Case number: ACP-324322-26

RE: SCA/02/26 Development under section 37l of the planning and development act 2000 at Tara Hall, Balcadden Road, Howth, Co. Dublin

Case No.: ACP-324322-26

Proposal: Substitute Consent for the retention of demolition at lower ground floor, ground floor and first floor levels and the substantially constructed part two/part three storey extension at the north elevation of the existing dwelling and a new on-site sepcon waste water treatment plant with sand polishing filter, and percolation area

Rev.	Date	By	Description
Scale	1 : 250		Job Title
Date	DEC. 2025		PROPOSED WORKS AT TARA HALL, BALSCADDEN ROAD, HOWTH, CO. DUBLIN
Drawn by	D.C.		Drawing Title
Org. No.	24-1471-02	Rev.	Client
			MR. JOHN ROE

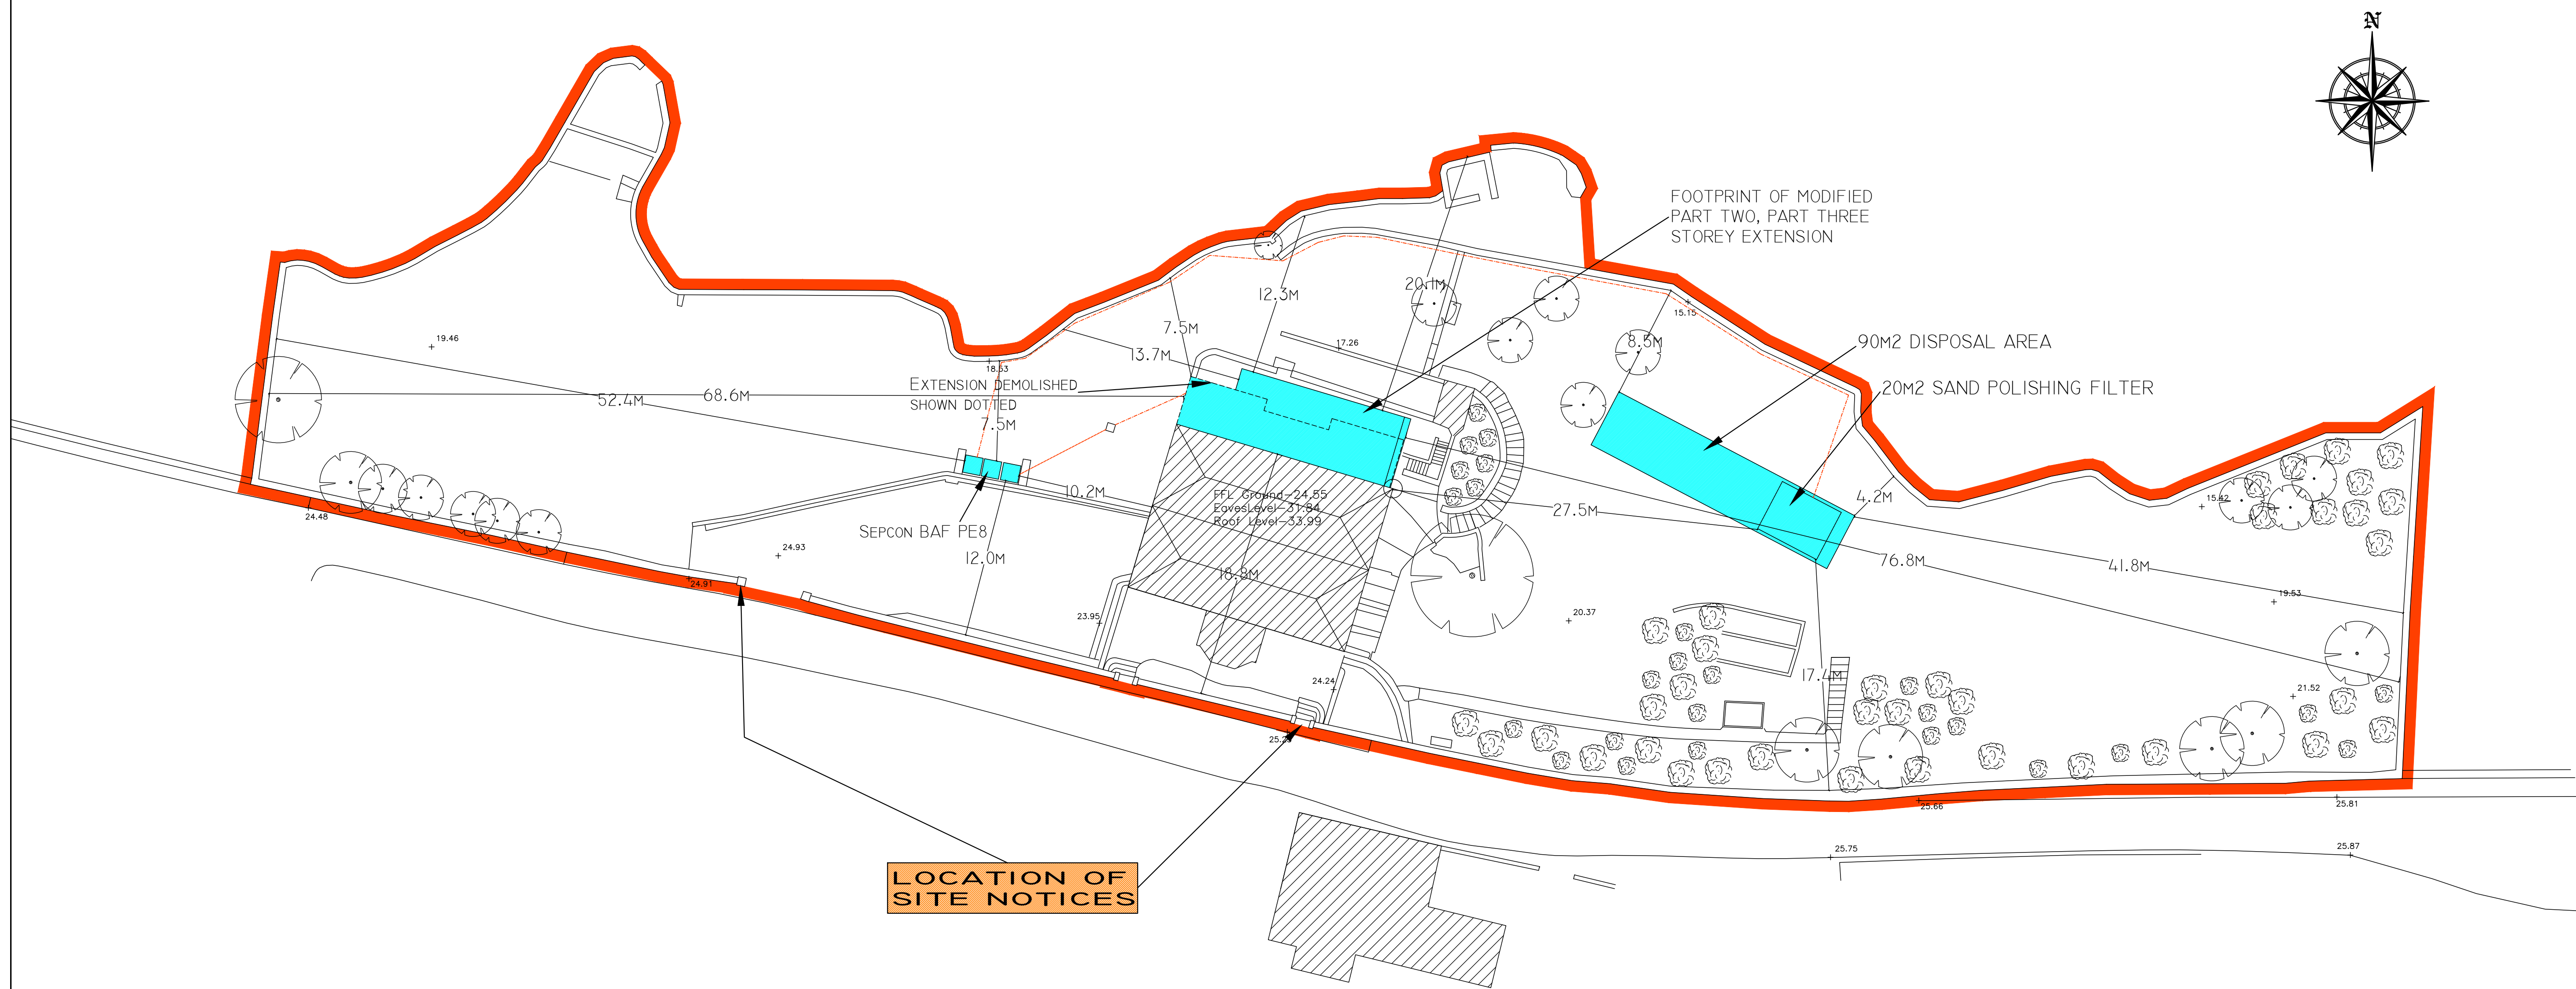
The Annex I habitat 'Vegetated sea cliffs of the Atlantic and Baltic coasts [1230]', is located 4.2m from the WWTP percolation area, as shown in the site layout plan by DaCaD Design, Drawing Number 24-1471-02. The wastewater system appears to be designed to allow wastewater to discharge via percolation into the ground. It is unclear what the quality of discharge will be at this point (discharge to percolation area) and if there is adequate depth of soil available to complete the treatment process, and if the soil itself is suitable in type, nature and depth to treat the effluent. Based on EPA mapping Rock is at or Near Surface (EPA, <https://gis.epa.ie/EPAMaps/>, accessed 02/07/26). Additionally, the Remedial AA Screening Report notes stone walls demolished onsite were used to "make up ground for the percolation area". This potential pathway for wastewater treated to an unknown standard, to seep/move downslope during the lifetime of the project towards the cliff face approximately 4.2m away north of the percolation area, is considered to present a risk to the Annex I Vegetated sea cliffs habitat which therefore requires further clarification and/or assessment. A hydrogeological and potentially a hydrological assessment should ideally inform the ecological assessment regarding potential impacts and risk.

'In response to the concern about the "quality of the discharge", the company that supplied the "Sepcon" Wastewater Treatment Plant was contacted on 19 August 2026 to clarify the quality of the discharge that is expected from the unit that provides primary and secondary treatment of the effluent coming from the house.

The WWTP is located on the other side of the house to the percolation area and is pumped to the sand polishing filter located on top of the percolation area. The treated effluent percolates through the sand polishing filter then through the percolation pipework and stone to the ground.

Once the treated discharge to the above standards is pumped to the sand filter it percolates through the sand filter to the percolation area below.

Parameter	Expected result after sand filter
BOD (Biological Oxygen Demand)	<5mg/l (Offer<1mg/l)
SS (Suspended Solids)	<5mg/l
NH ₄ (Ammonia)	<5mg/l
Pathogens (eg E.coli)	>99 reduction

.... In the last report submitted to An Coimisiún Pleanála in late July this year, a site characterization report and survey of the percolation area with sections demonstrating the depths of soil under the percolation stone were provided. Both sections demonstrated an average of 1.15m depth rising to 2m depth of soil over rock.'

With consideration of the above, it is considered that the onsite wastewater treatment system will treat wastewater adequately and that there is adequate depth & quality of soil to facilitate the process.

As a precautionary measure, it is proposed to monitor the soil (orthophosphates and nitrates) down slope of the percolation and sand filter area for a period of five years post-development to ensure the treatment system is operating to specification. The results of this monitoring will be submitted to Fingal Co Co on a regular basis as agreed. If it is determined that additional mitigation measures to limit the nutrient input into the soil are required after any monitoring period, these will be agreed between the client and the council.
